Please upload onto Ocella the email below and the substitute plans (attached) for application **R/45/21/HH**.

I am the agent for the above application.

Proposed Elevations & Roof Plan

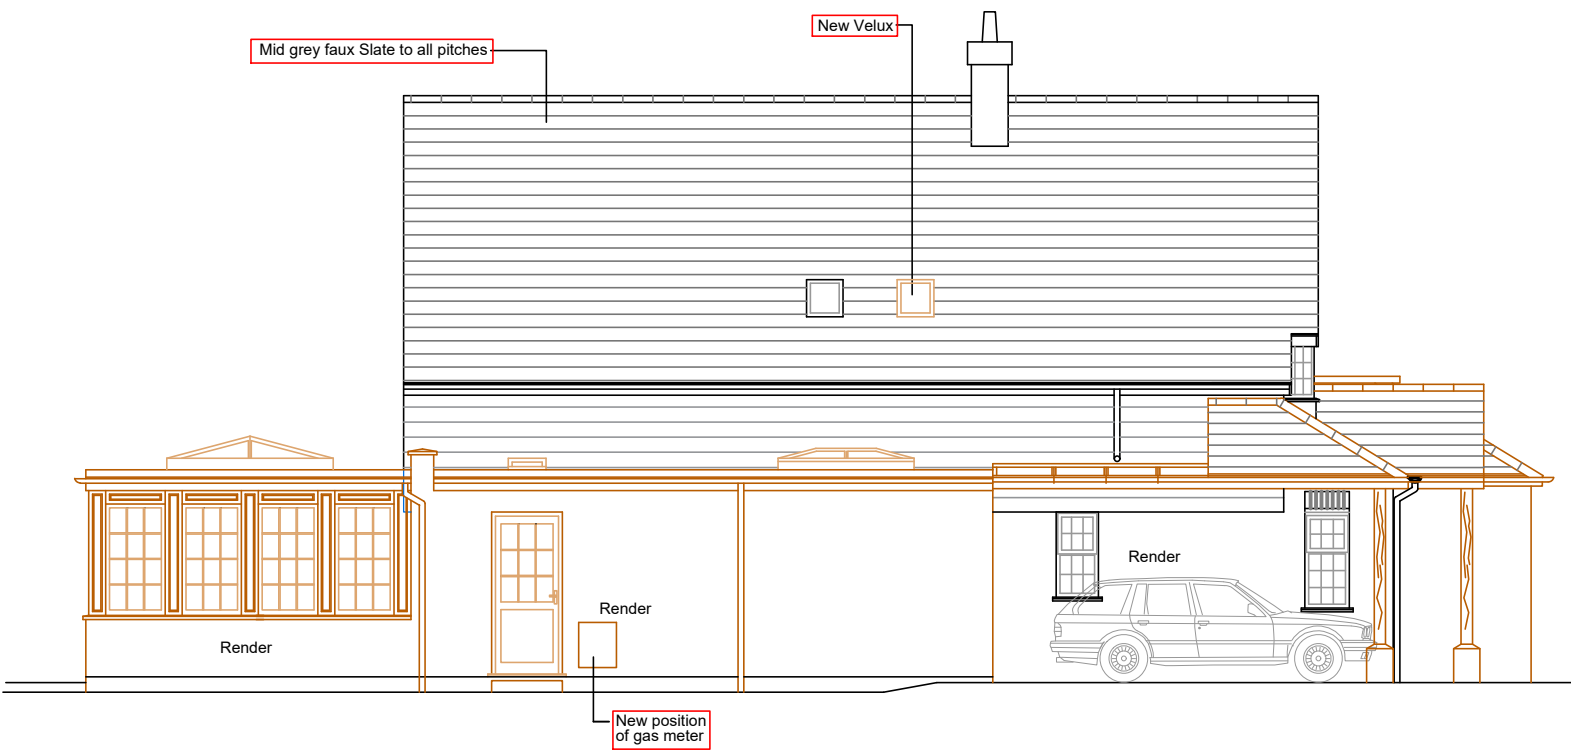
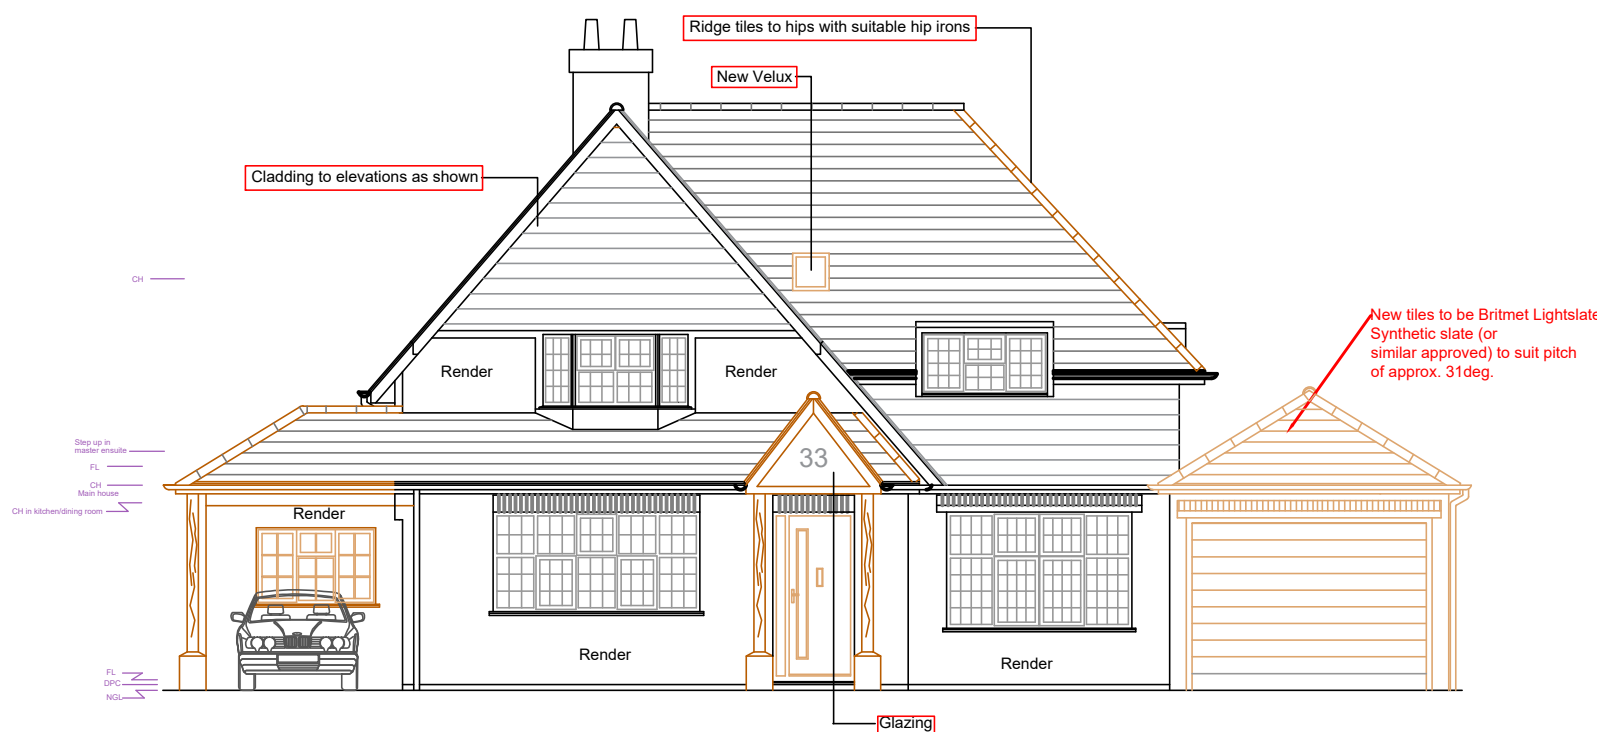
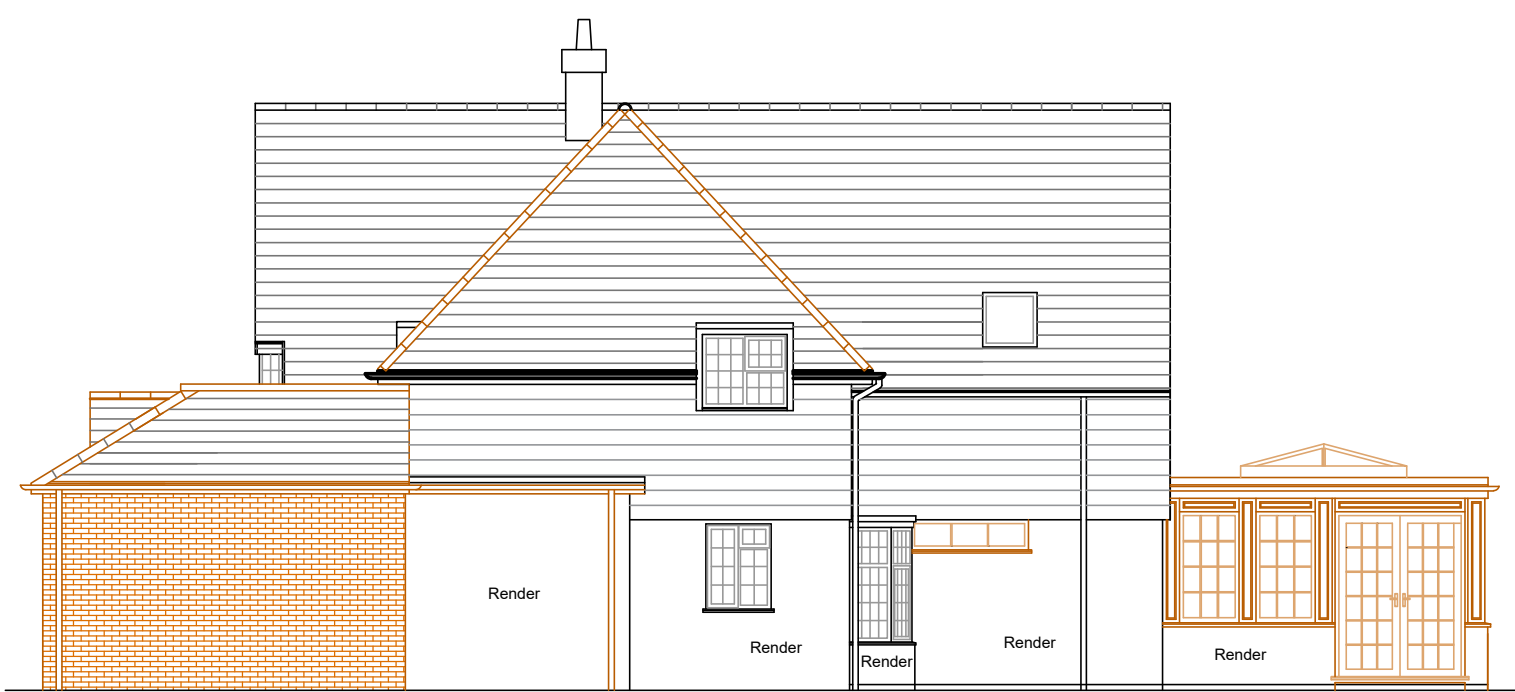
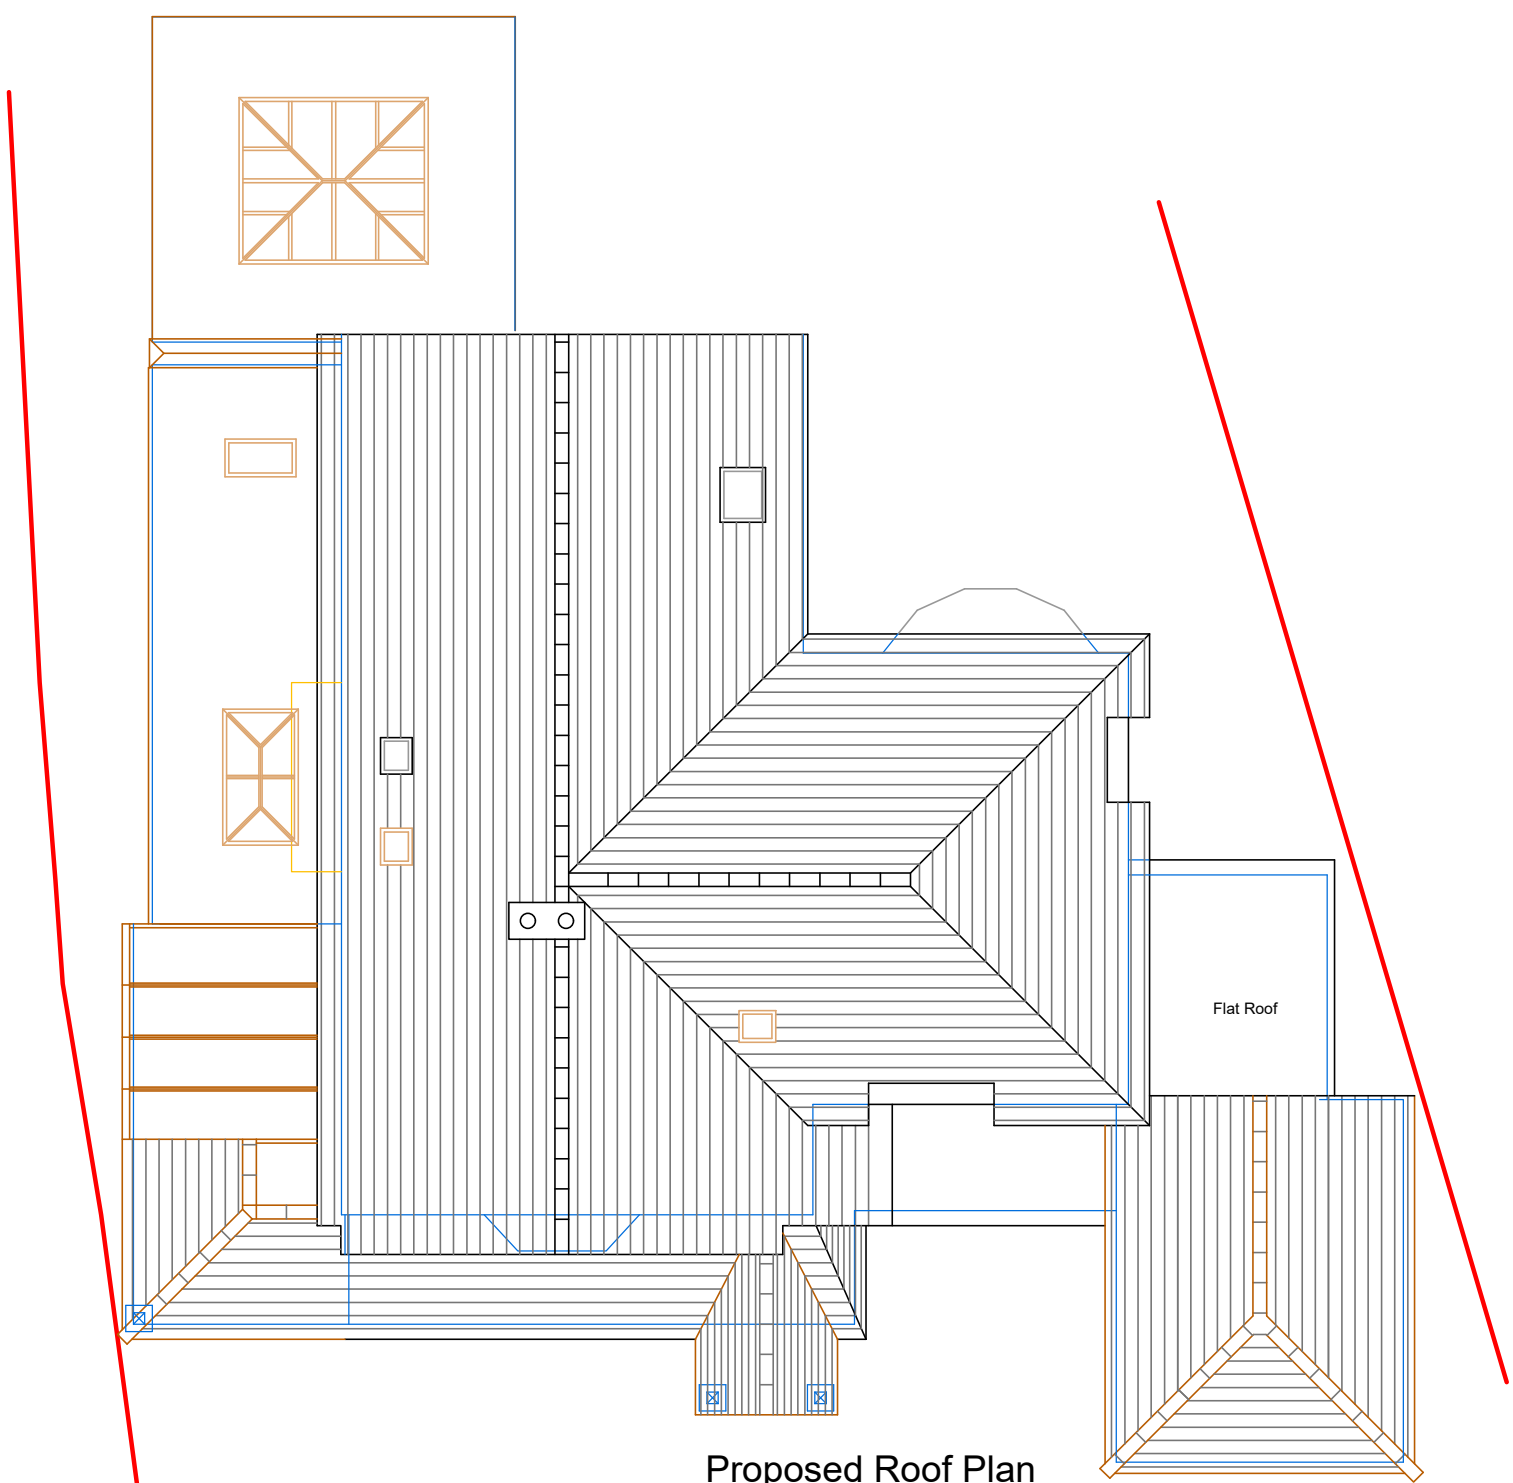
After discussion with Building Control and the Client it is intended to make a small change to the design in that the roof to the extension to the garage is now shown as going to a full pitched roof rather than the pitched parapet shown on the submitted plans. This increases the overall height of the garage extension by a mere 200mm. However, we believe this is a better, more fluent design for this roof and will be easier on the eye and easier to construct to a good standard of robustness, especially in terms of waterproofing and maintenance.
